Subject: A/55/19/PL

A/55/19/PL is exactly the same as the previous refused application A/31/19/PL.

Site Location Plan (1:1250)

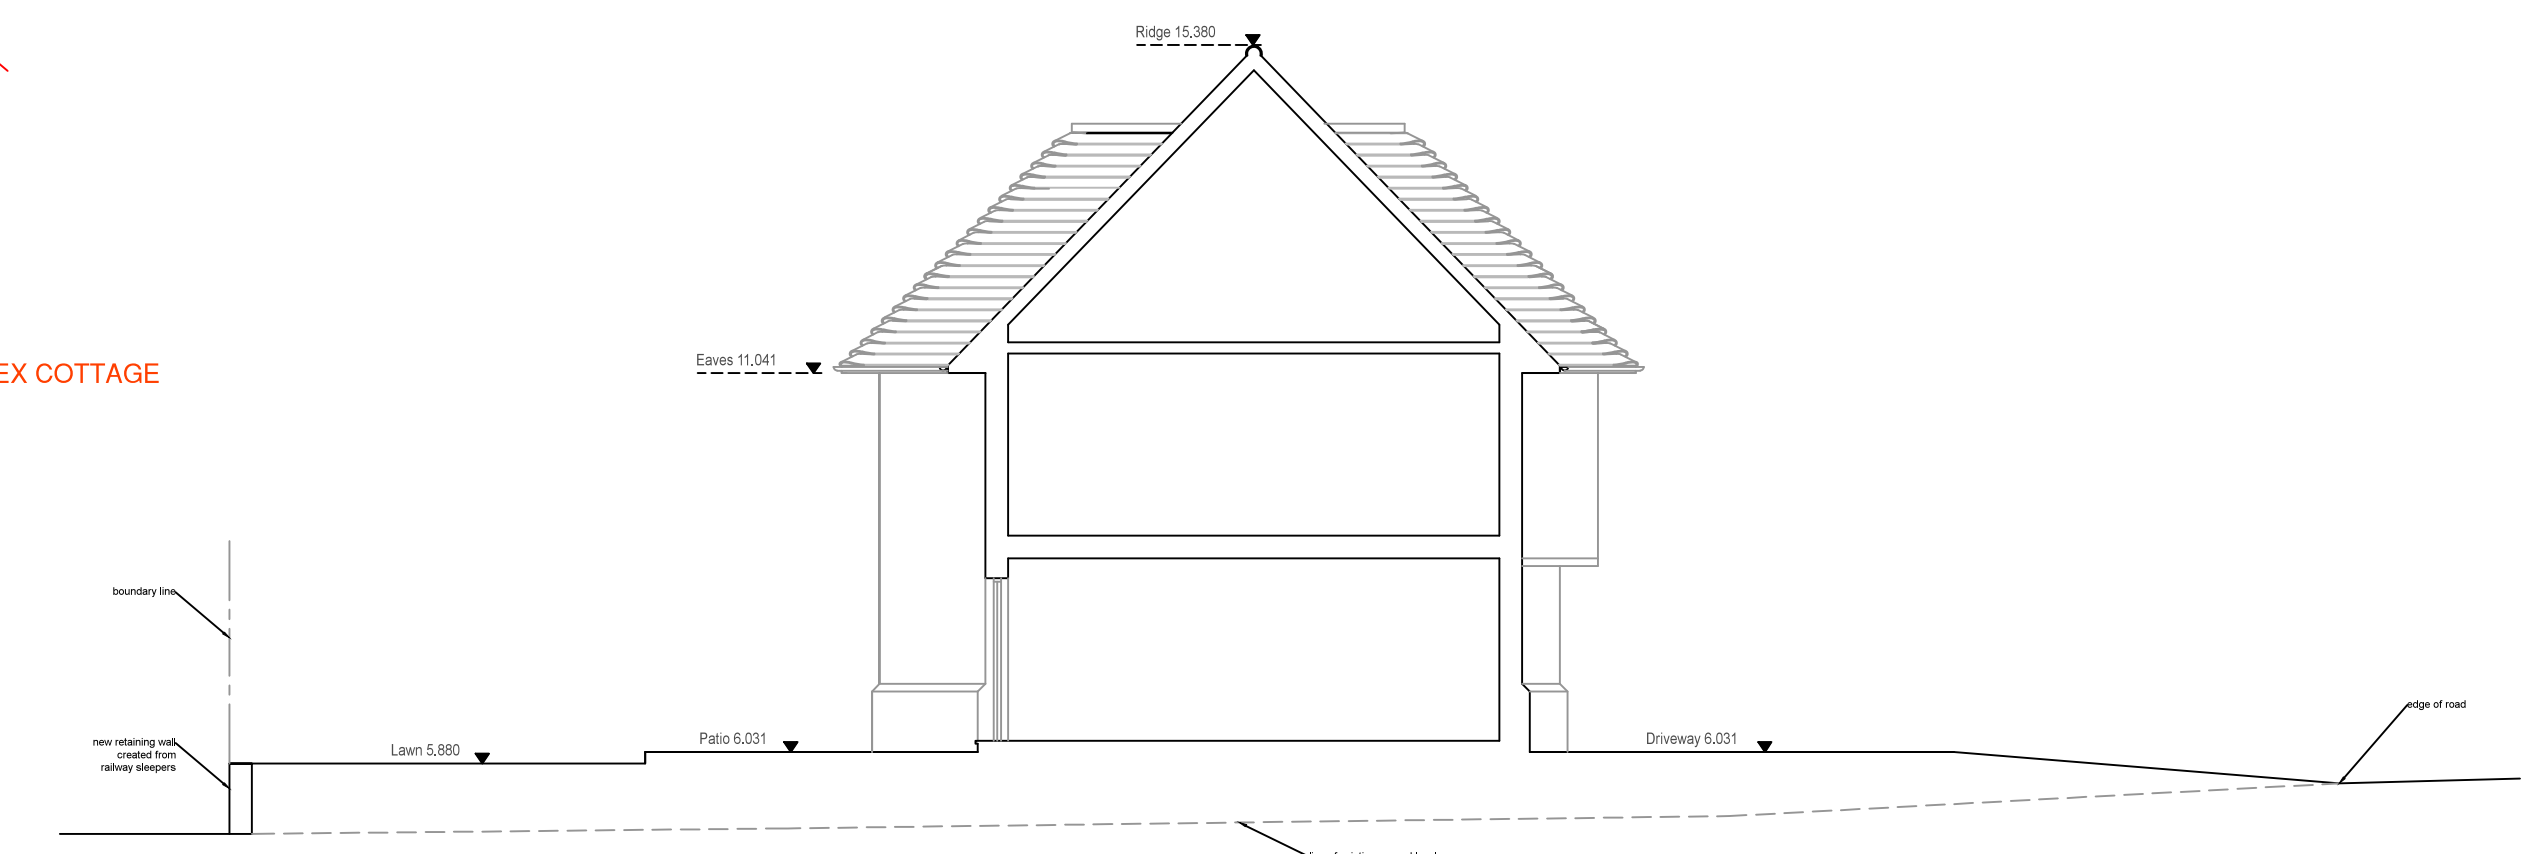
It has moved the 2 m way from the Ashurst boundary requested in your Recommendation Report. However it has moved further out on the western boundary taking it into local green space.

Client: Mr & Mrs Jones
Project Address:
Land at the 9th Tee
Ham Manor Way
Angmering
Drawing Title:
Proposed Plans, Elevations and Street
Scene Elevation
Drawing Number: 1202.01.d
Scale: As stated printed @ A1
Date: 06/02/2019

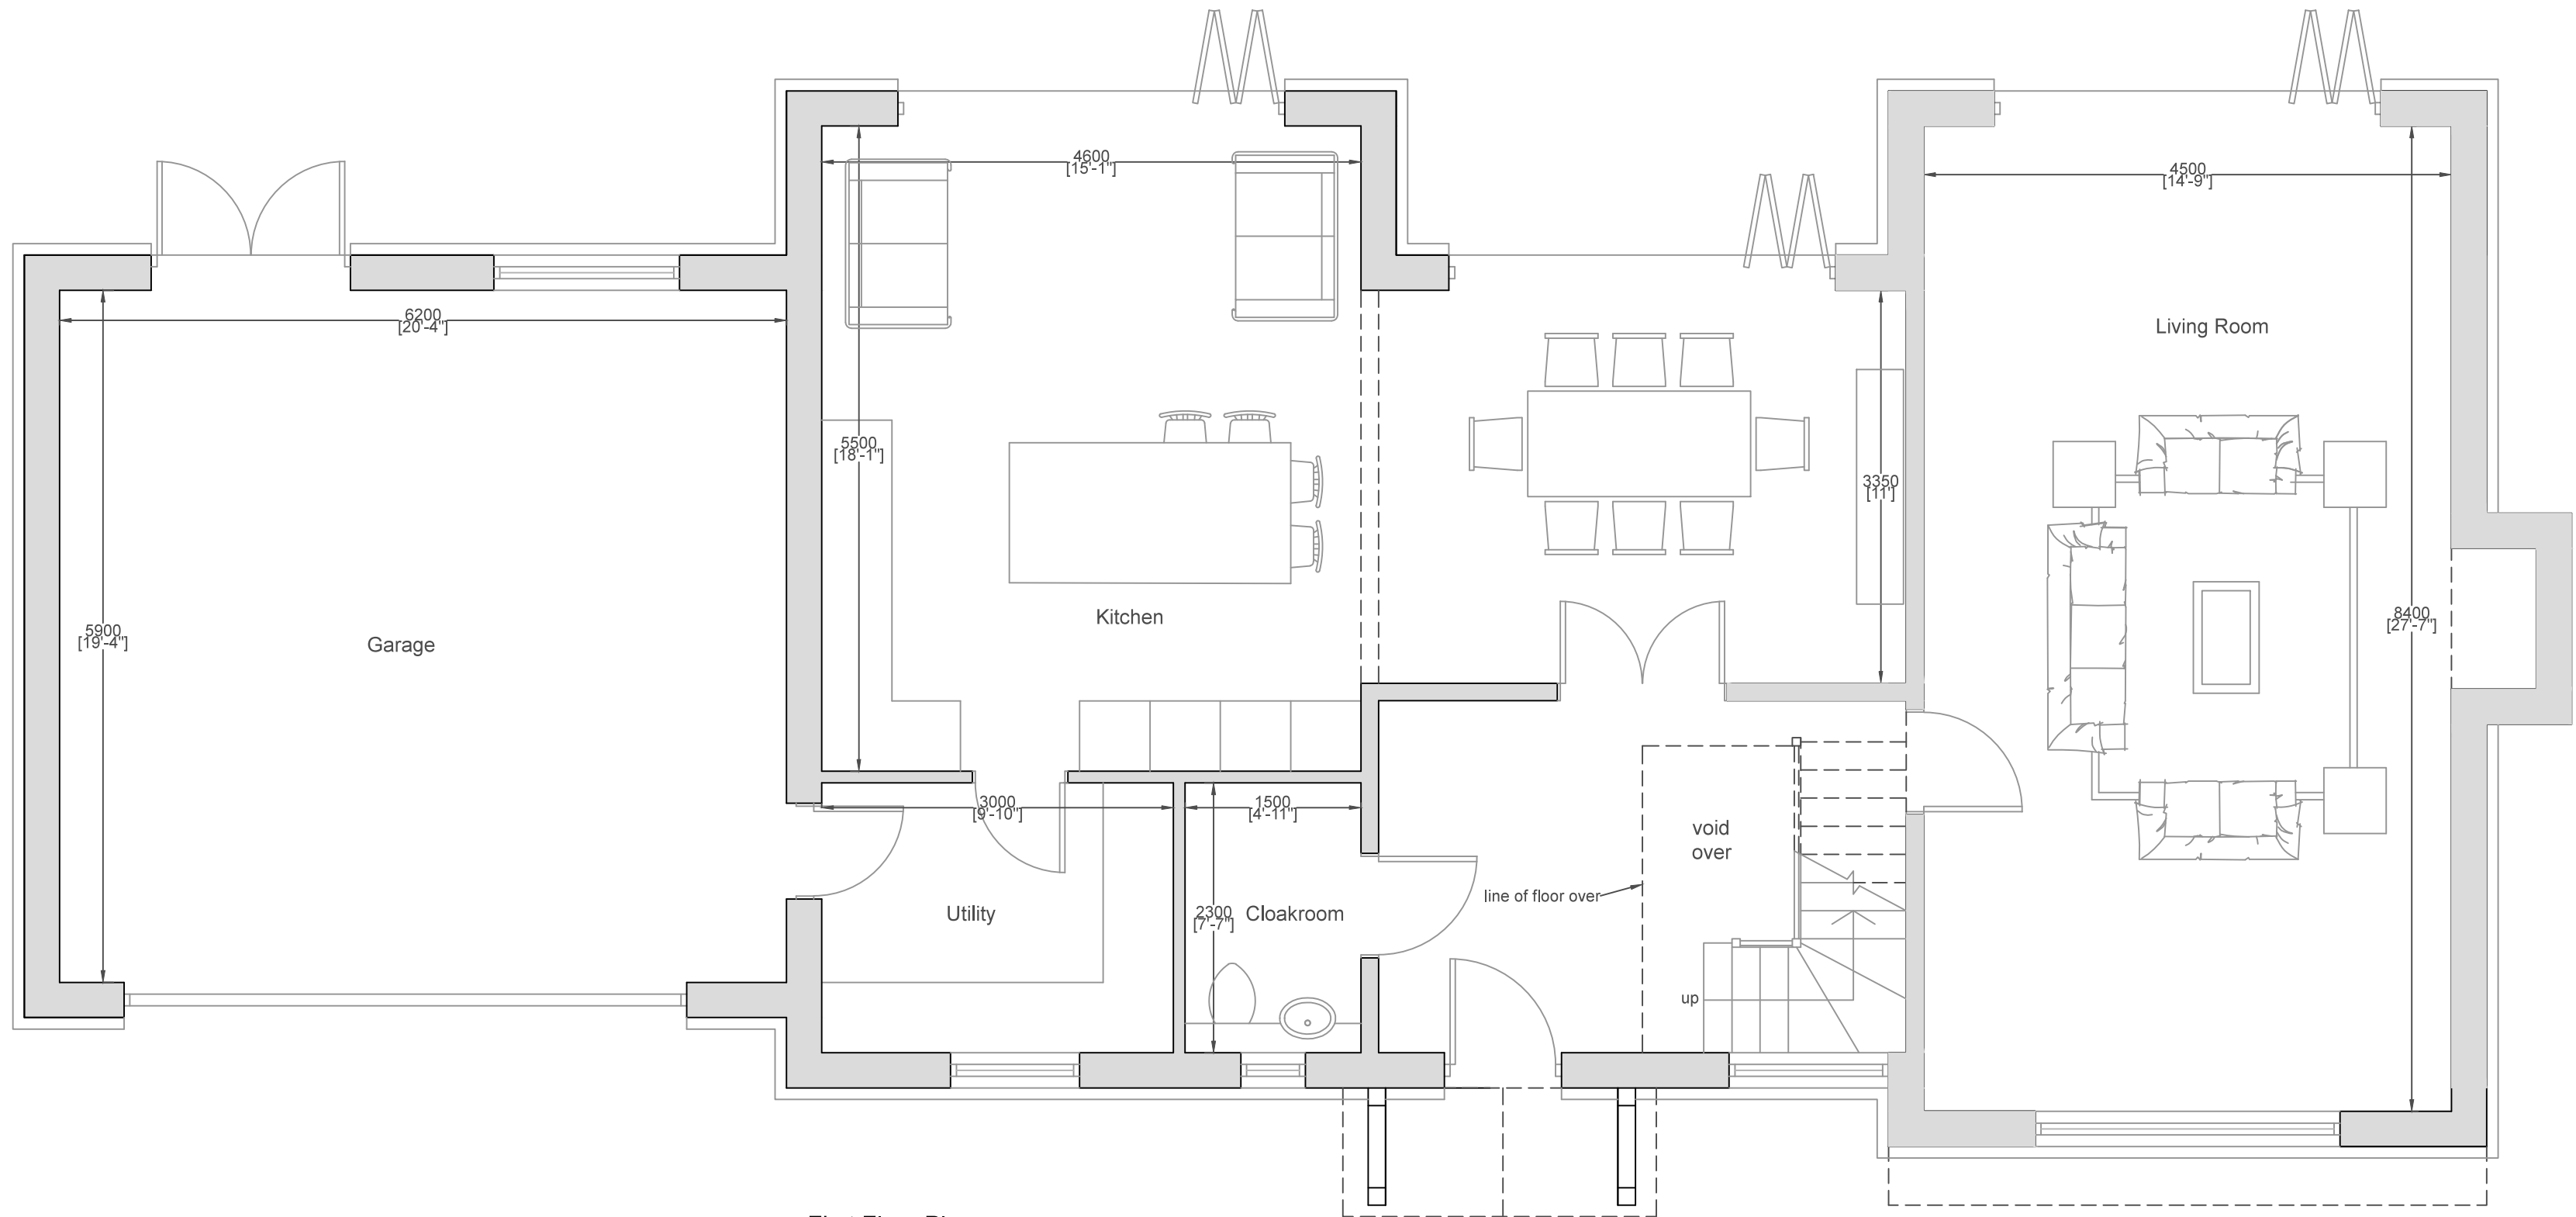
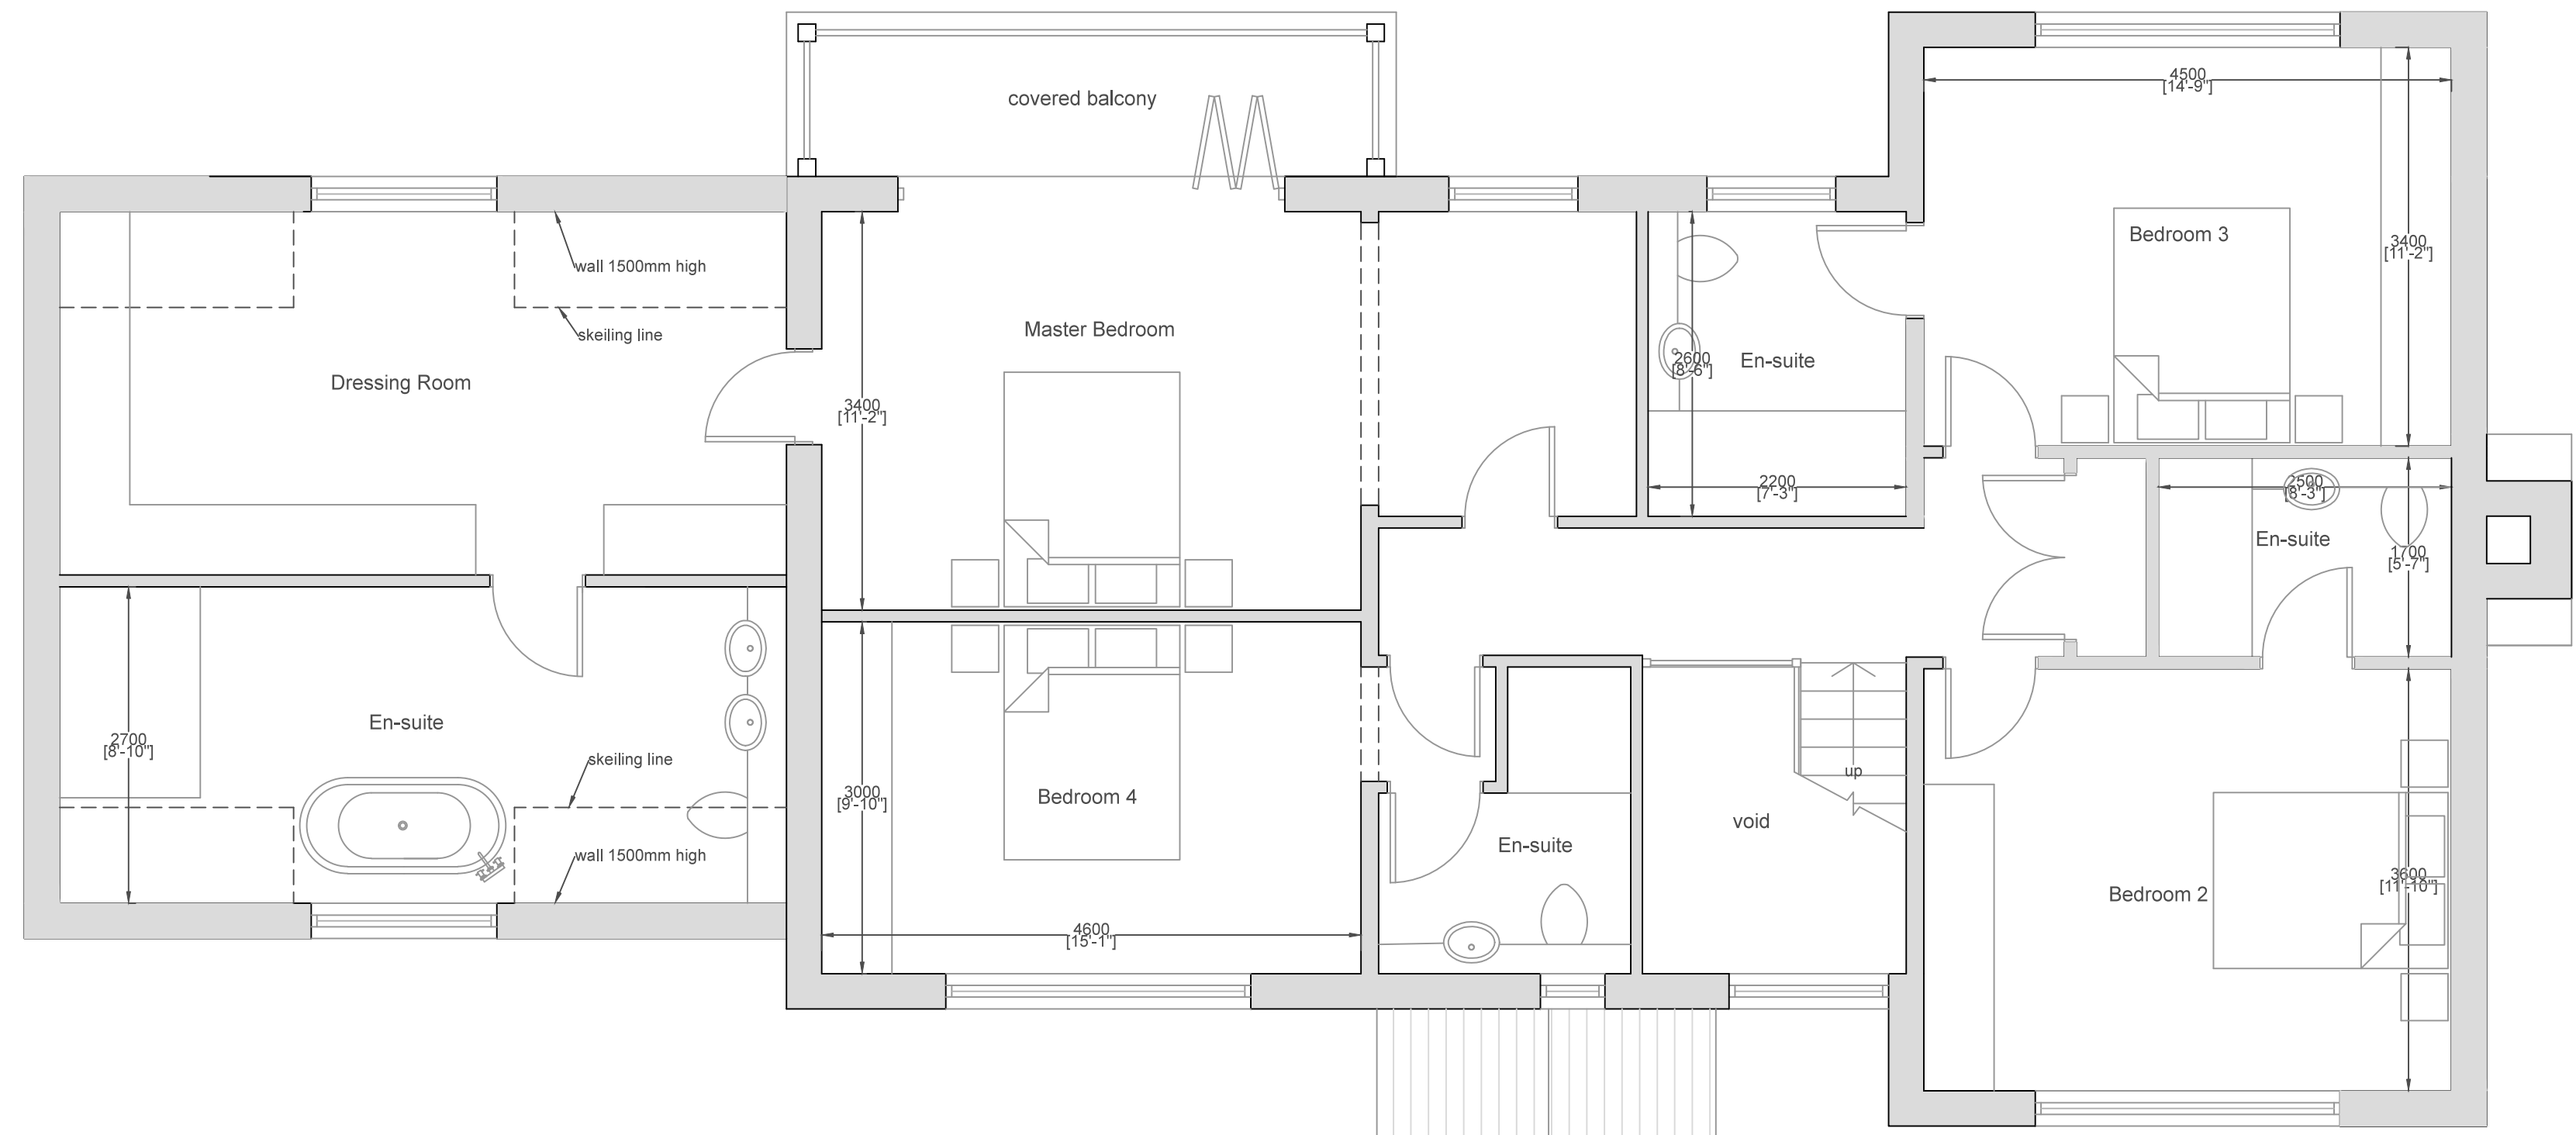
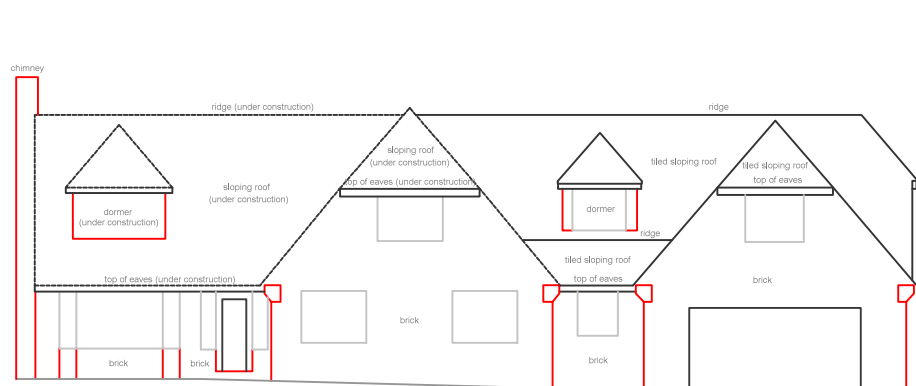
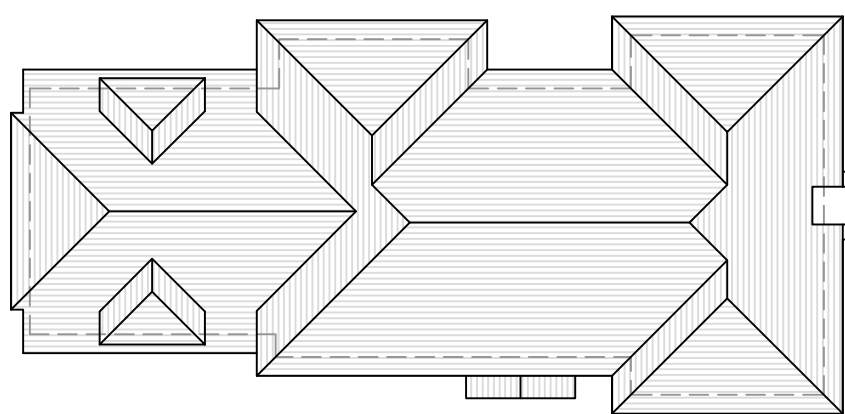
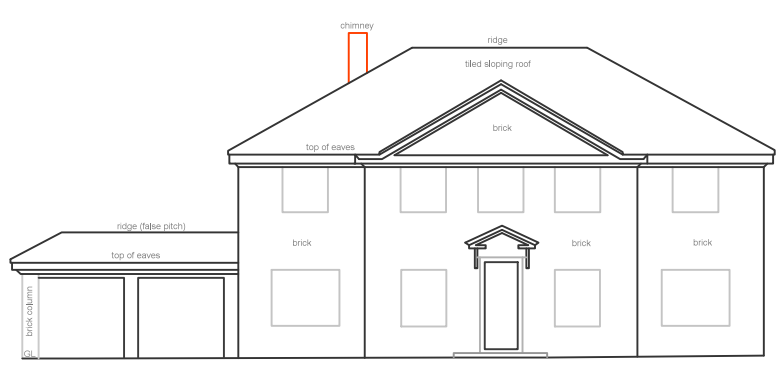
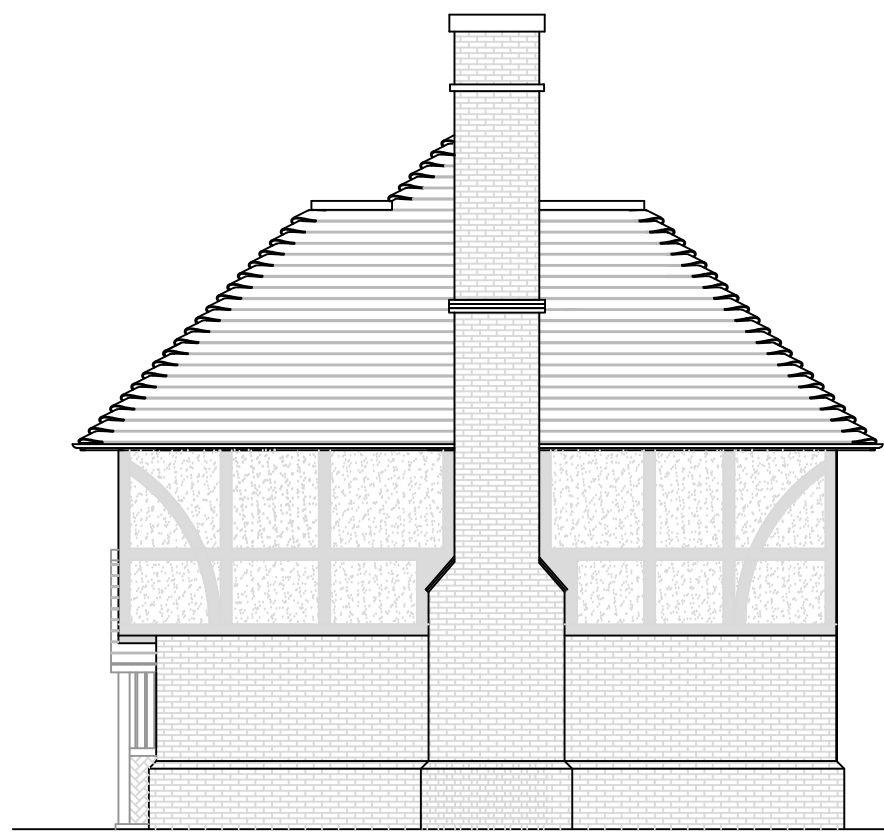
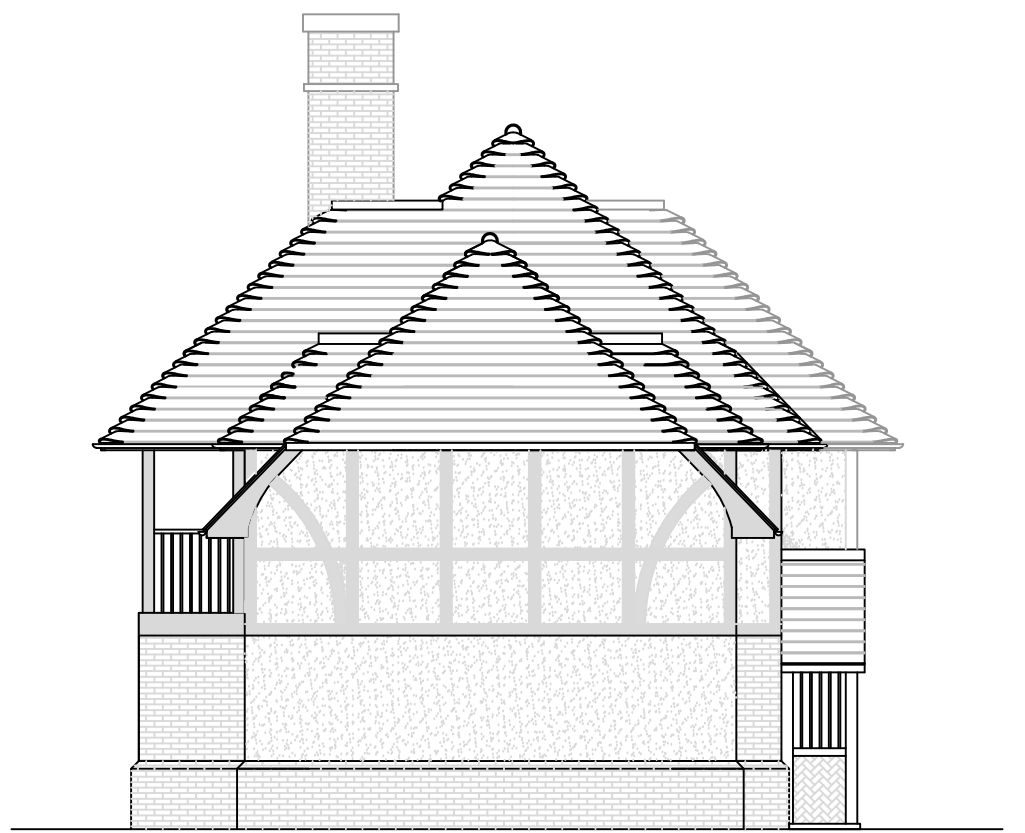
The size and design however has not changed and conflicts with policy DDM1 of the Arun Plan and HD5 of the Neighbourhood Plan.

It clearly does not achieve this requirement as it does not emulate in any respect the chalet bungalows opposite that have been established for some 60 years.
